Subject: RE: Springfield, Hook Lane ref AL/112/21/DOC

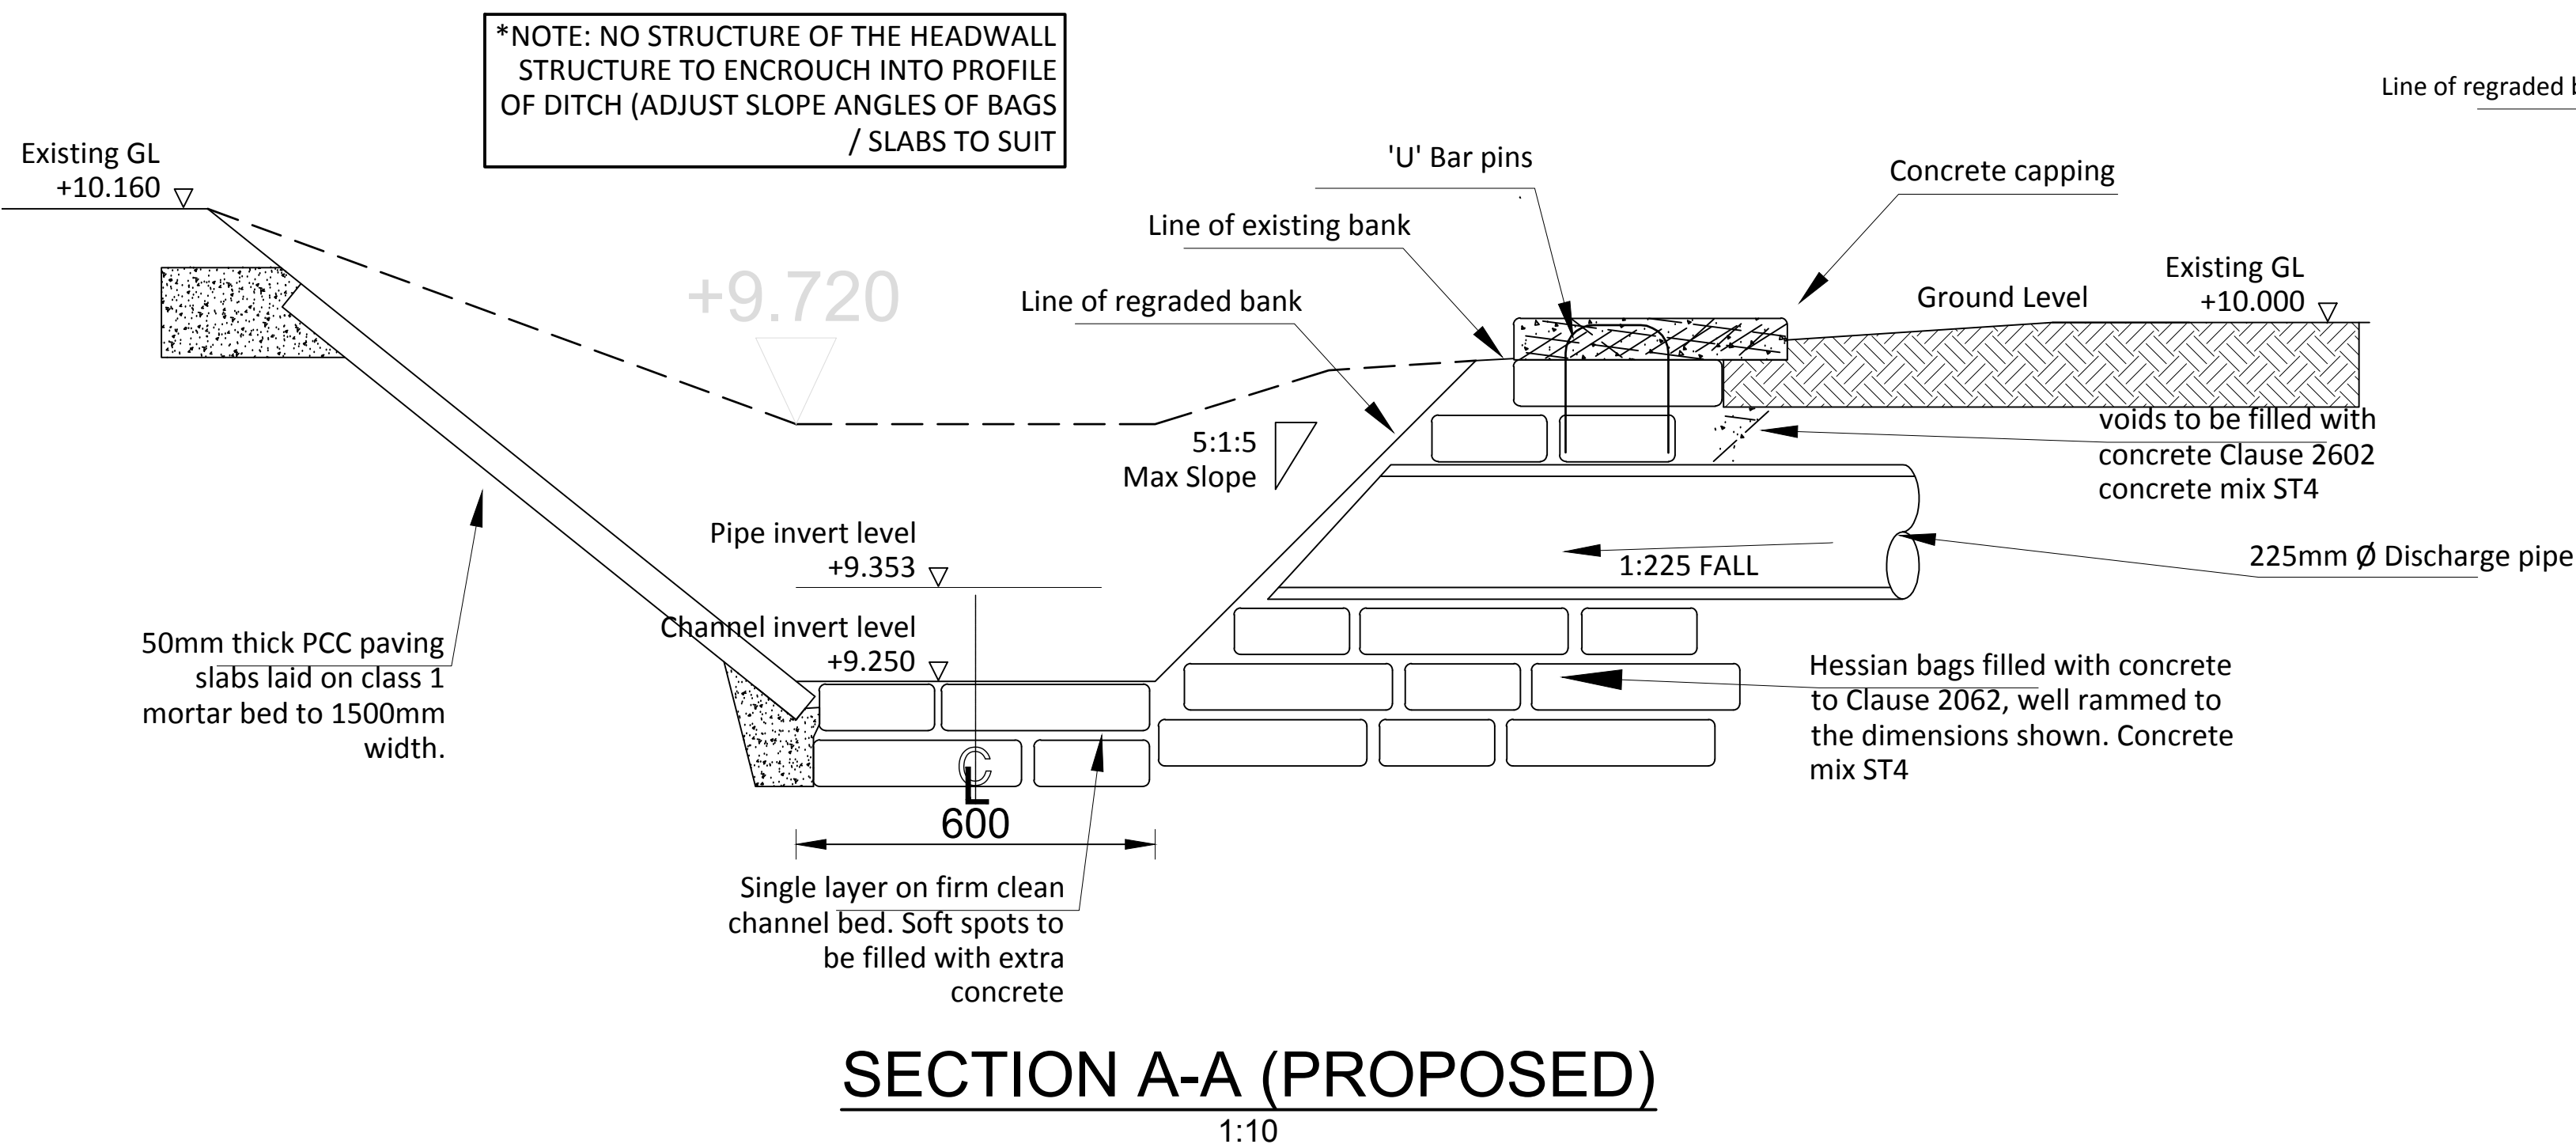
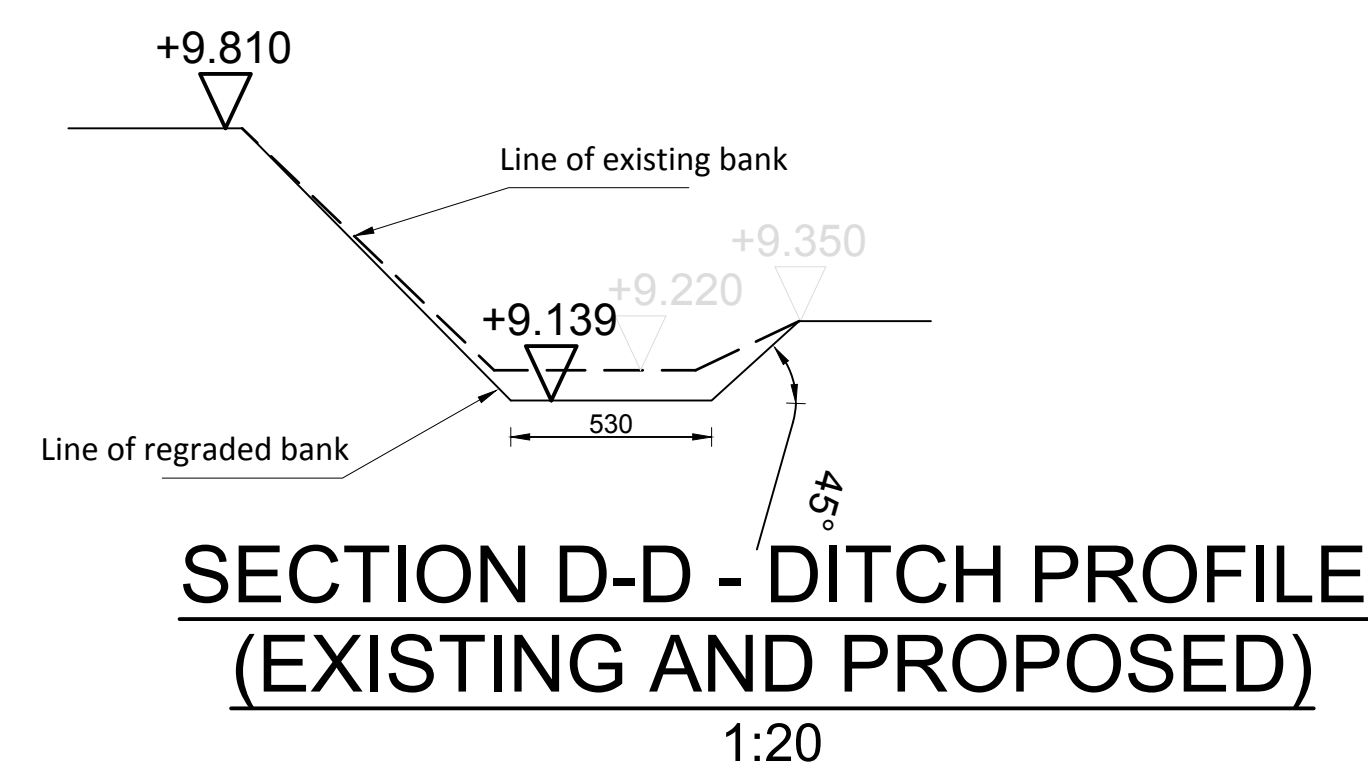
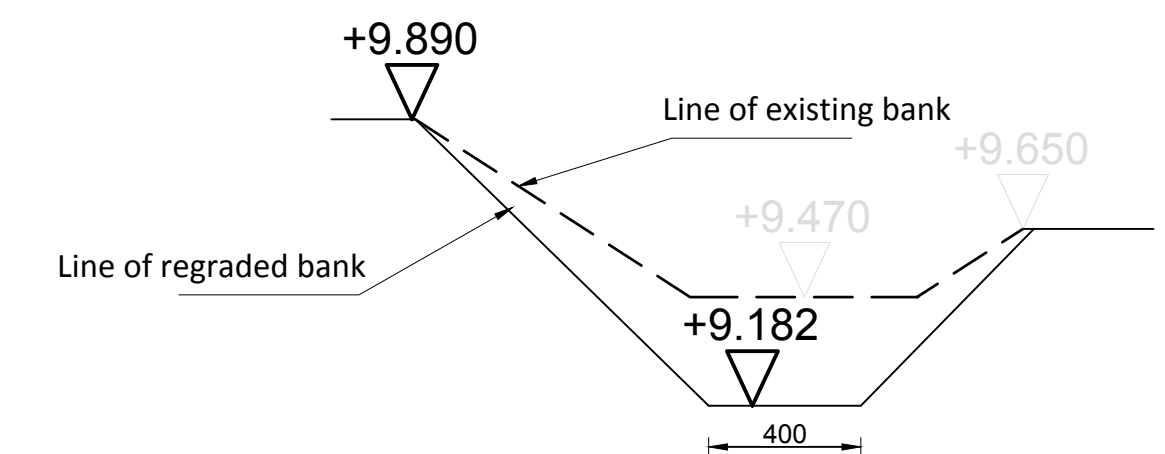
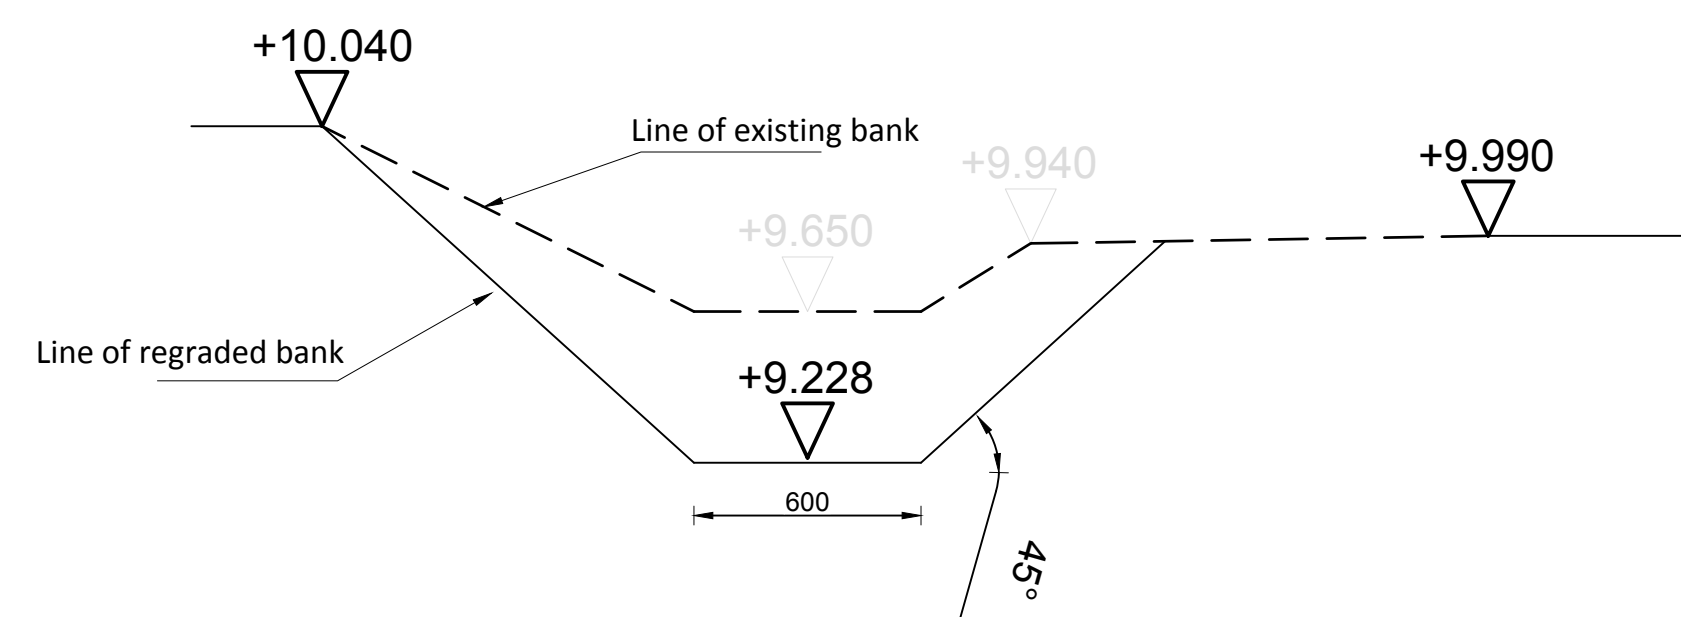
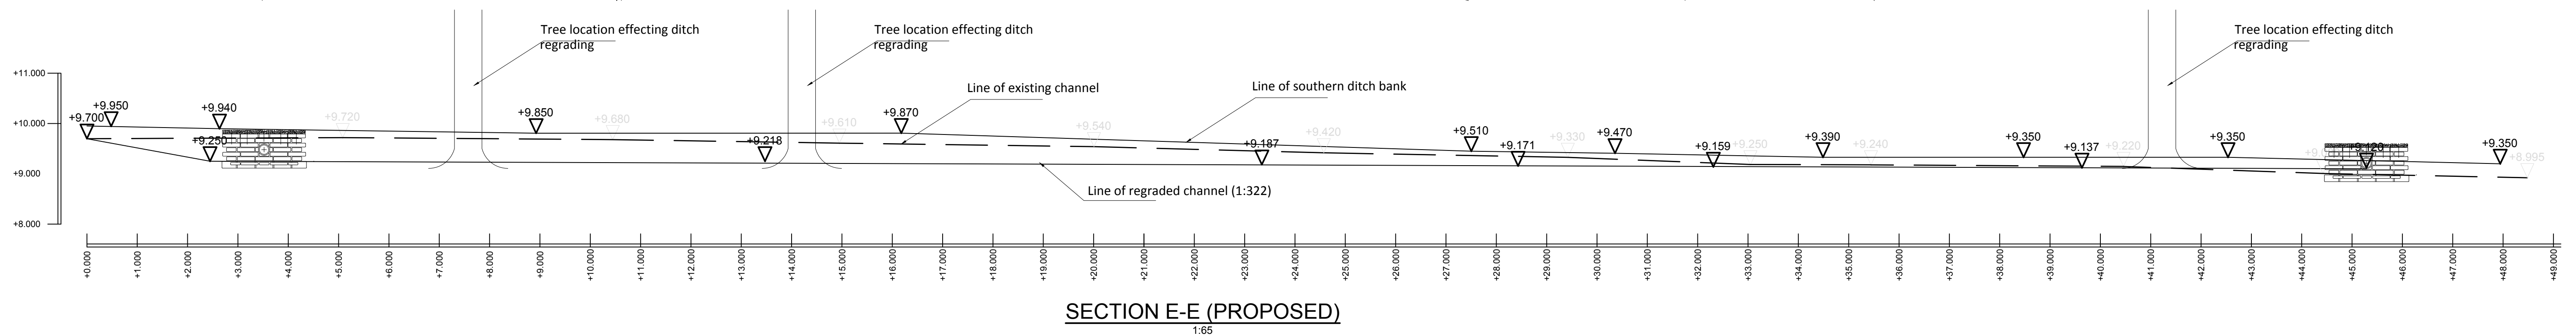
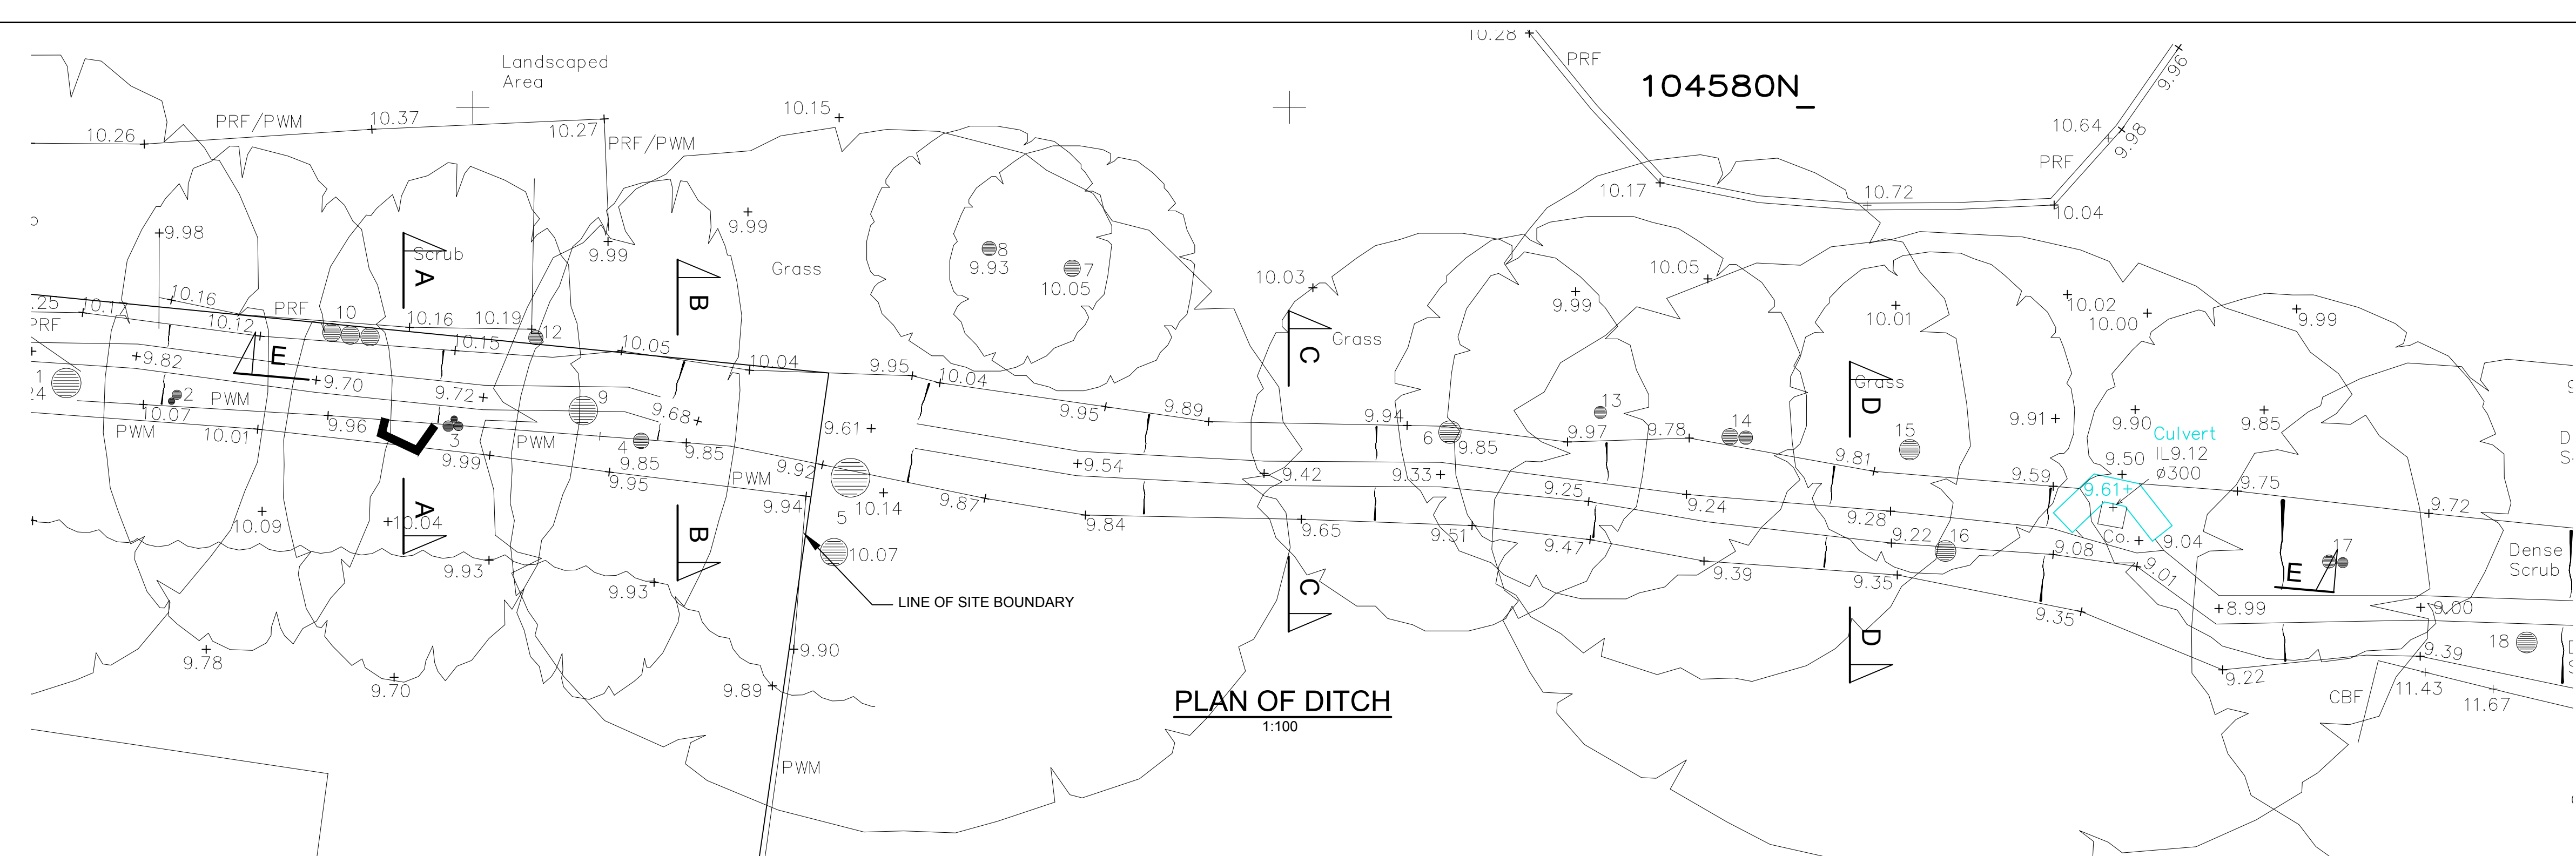
Please detail what section of watercourse the management company will have riparian responsibility for, include a plan in an appendix which clearly shows this. Please detail what riparian responsibility is and why maintenance of the ditch is important. Please update ditch maintenance table to remove references to elements which are not relevant, e.g. filter strip.
